REQUEST

Current Zoning: N1-C (neighborhood 1-C) and N2-B (neighborhood 2-B)
Proposed Zoning: UR-2(CD) (urban residential, conditional)

The petition proposes to rezone a vacant parcel in the Plaza Midwood neighborhood to allow 18 single family attached residential units.

SCHEMATIC SITE PLAN

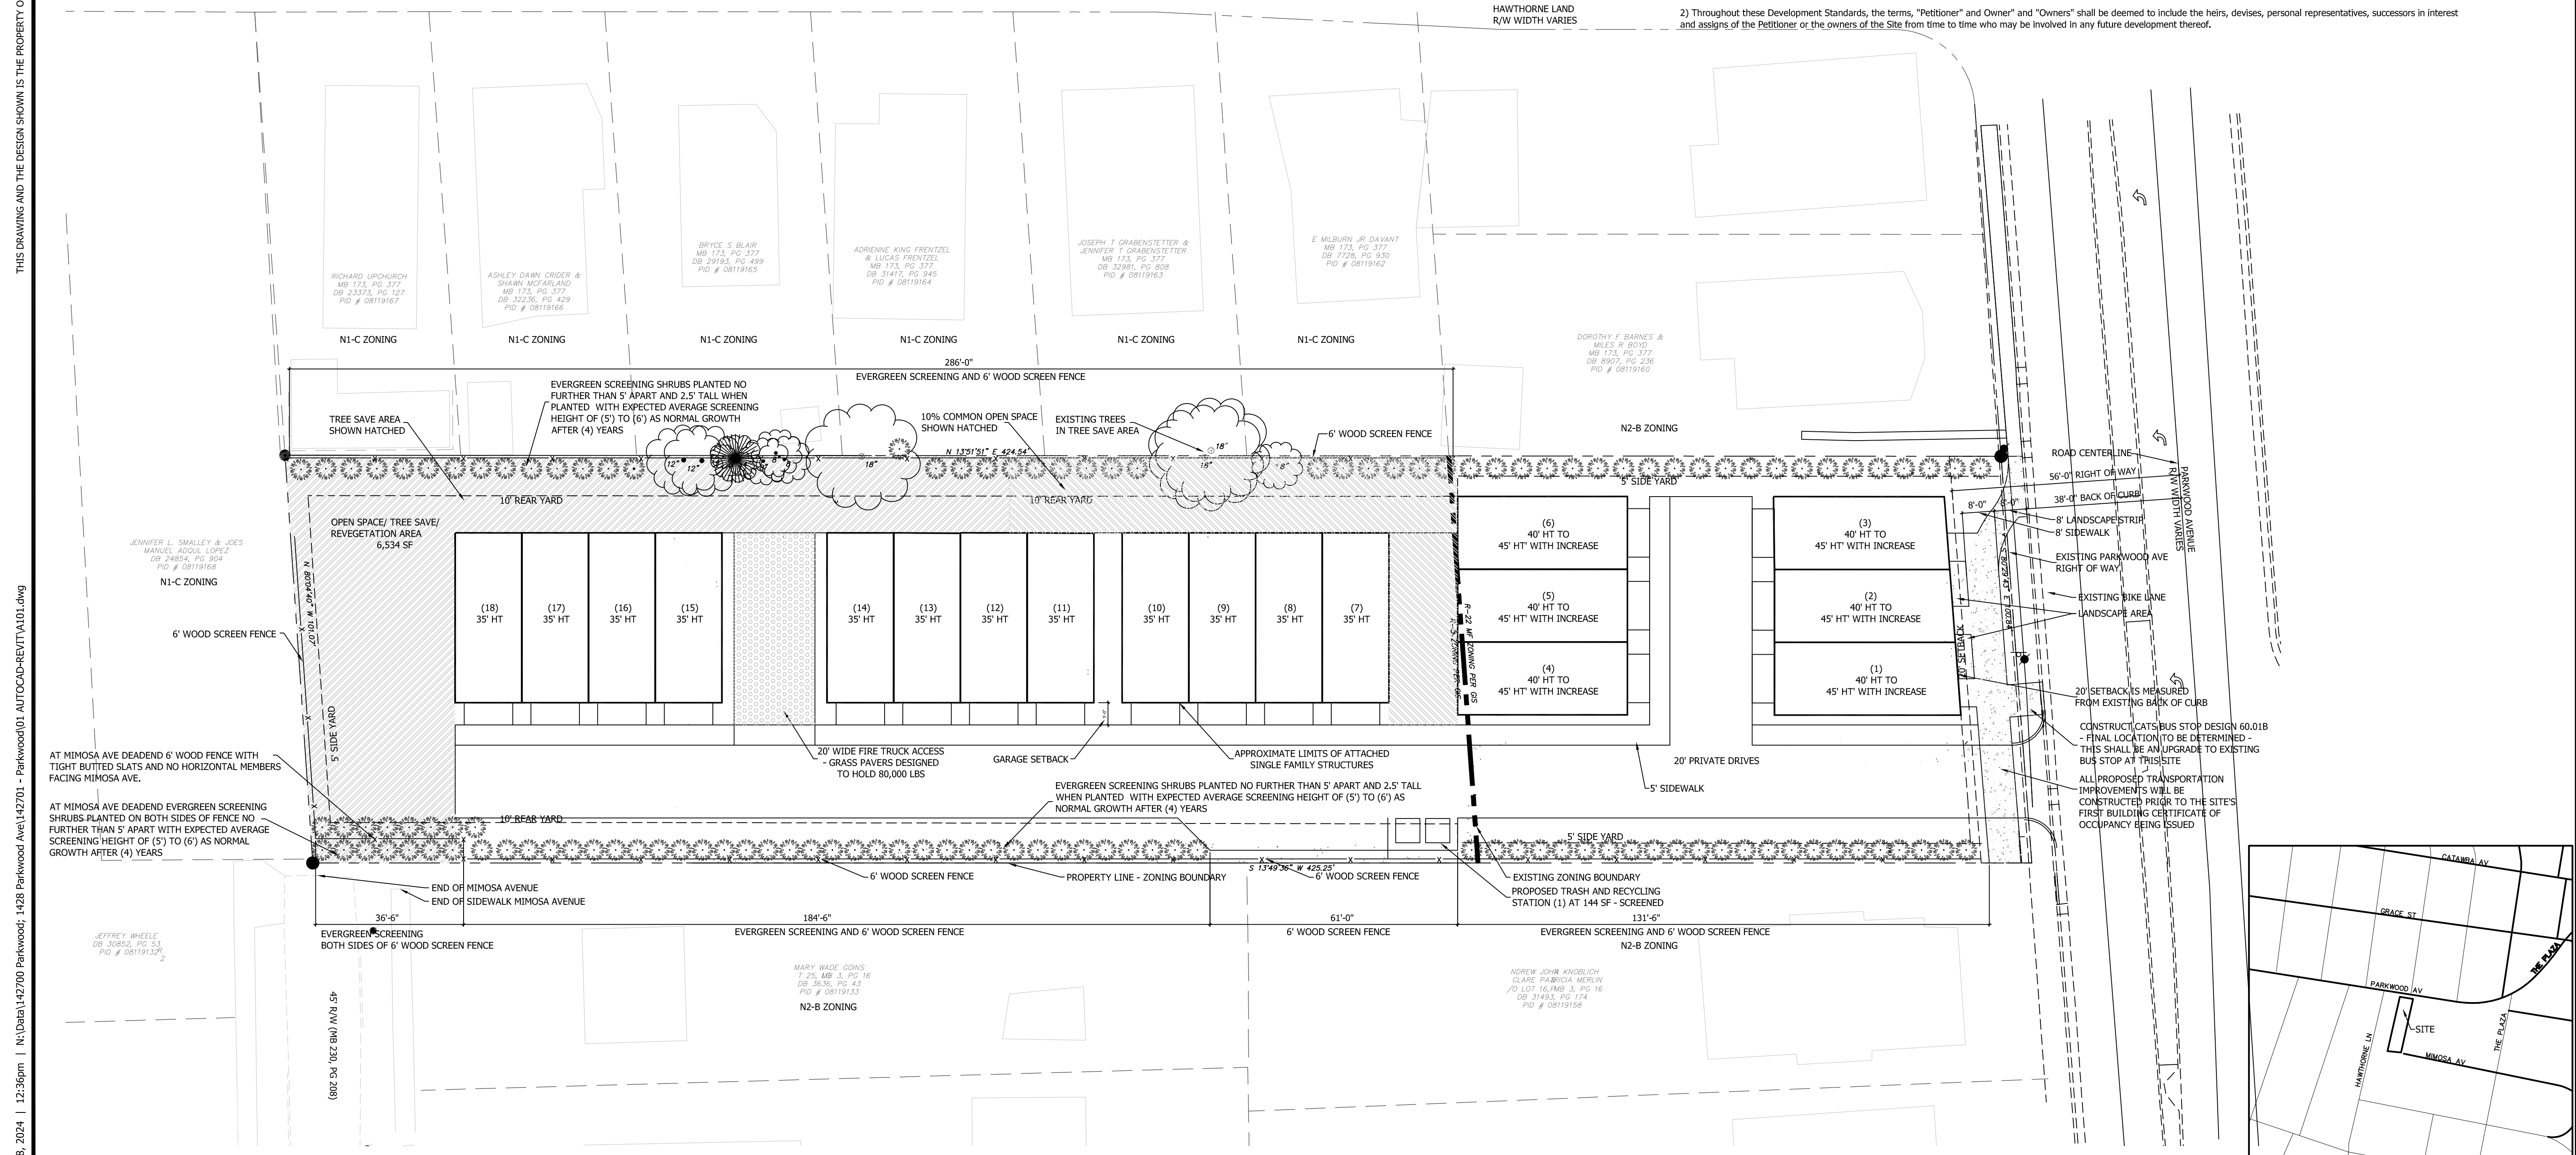
- ~~1. Label and dimension the existing and future curb and gutter from the centerline for each road on the site plan. Streetscape elements should be constructed at the back of future curb and gutter.~~

- ~~2. Revise site plan and conditional note(s) to commit to dedicate 56 feet of right of way from the road centerline. The site plan shall label and dimension the right of way from the road centerline.~~

- ~~3. Site plan only shows hatched area, petitioner should label and dimension the right of way from the centerline for each road on the site plan.~~

- ~~4. The site is located on CATS local bus route #4 along Parkwood Avenue. CATS requests the construction of ADA compliant bus stop type 60.01B. The final location will be determined during the Land Development plan review process. This shall be an upgrade to the existing bus stop at this site.~~

- ~~7. Please provide the width and location of the landscape screen clearly. Please ensure it noted and all the required plantings in landscape screen areas clearly defined. Add a development note committing to the landscape screen details along the east and west property lines. **Update:** Transportation Note 12 should be placed under Landscaping and Screening heading. The language should clearly identify where both~~

~~plantings and fence will be provided, and where only fencing will be provided. Please include the width of the screening (i.e. minimum 5 feet, 10 feet, etc.).~~ Addressed

~~9. Please show staging area/how the dumpsters and recycle carts will be serviced on the site.~~Addressed
Environment

~~10. **New comment:** Fire Truck Access cannot be counted towards tree save requirements.~~ Addressed
